Ribble Valley Borough Council
Housing & Development Control

Application no: **3/2020/0723**

Address: **6 Southfield Drive, West Bradford, BB7 4TU**

Proposal: **Proposed first floor extension over existing garage with a change in roofline to the existing rear extension.**

**1 PROPOSED GROUND FLOOR PLAN**  
1:100 @A1

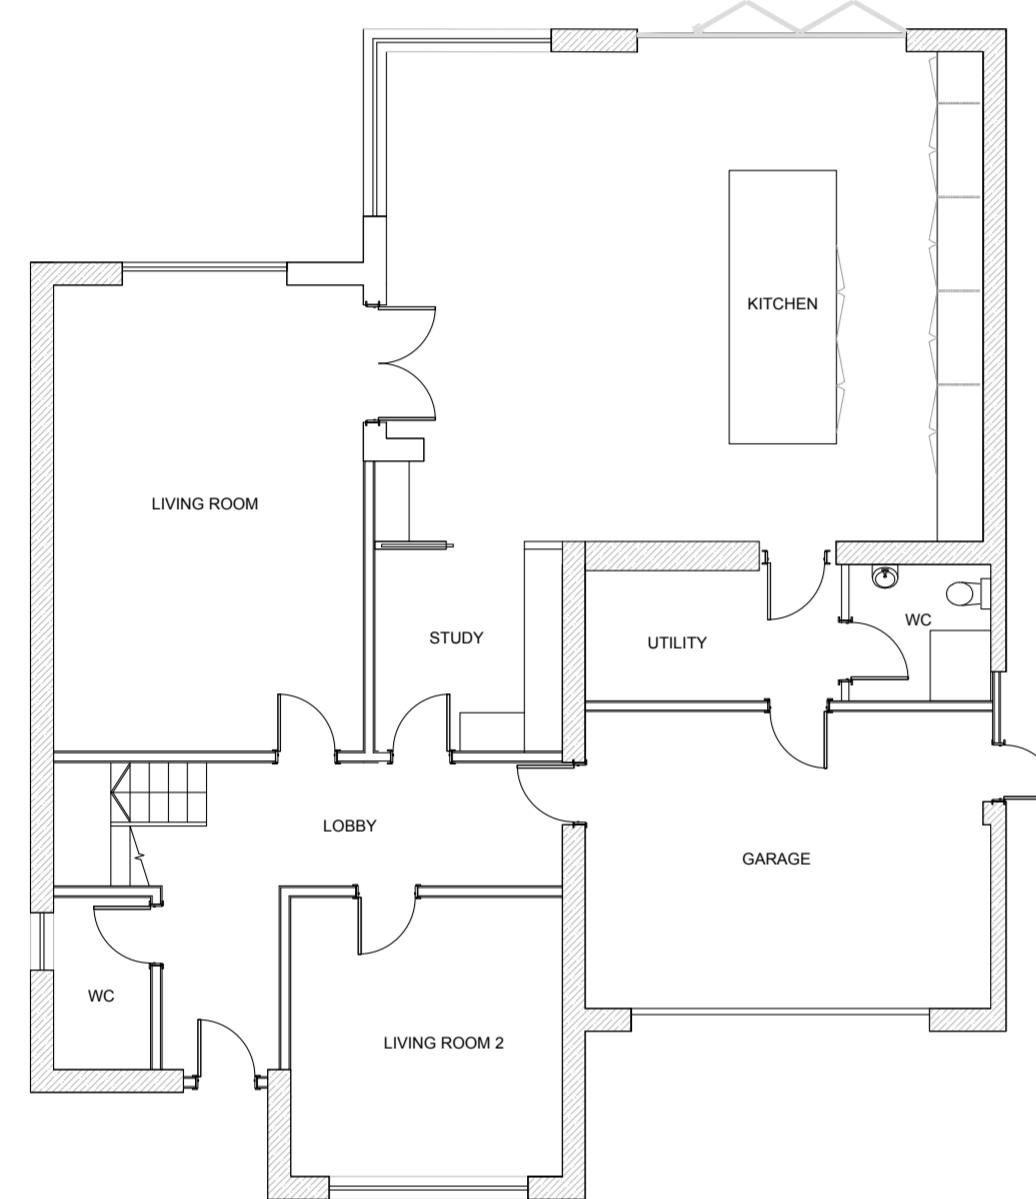
Whilst the Local Highway Authority would raise no objection to the principle of the development proposal, there will be an increase to the existing parking provision as a result of the proposal, and therefore the applicant is required to demonstrate how they can accommodate three off-street parking spaces within the curtilage of the property.

The Local Highway Authority requests that the plans are revised.
